CITY OF ALBUQUERQUE

**Planning Department
Transportation Development Services**

**Re: Duplex Dwelling
172 Monte Largo NE
60-Day Temporary Certificate of Occupancy- Transportation Development
Engineer's/Architect's Stamp dated 3-13-15 (L23-D008)
Certification dated 3-13-15**

TRAFFIC CIRCULATION LAYOUT
(CERTIFICATION: MARCH 13, 2015)

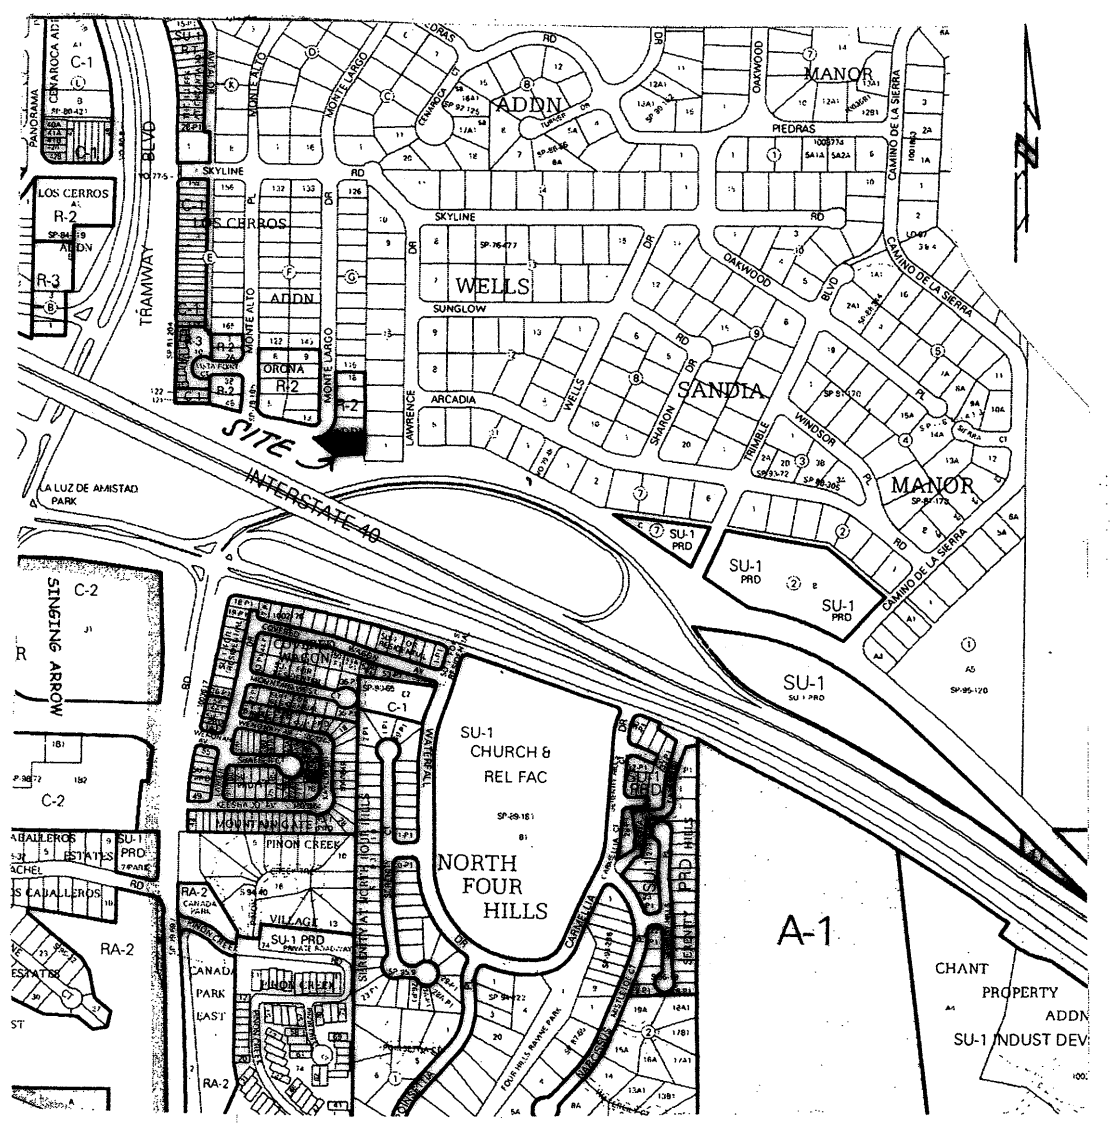
- Installation of ADA sign per TCL plan.
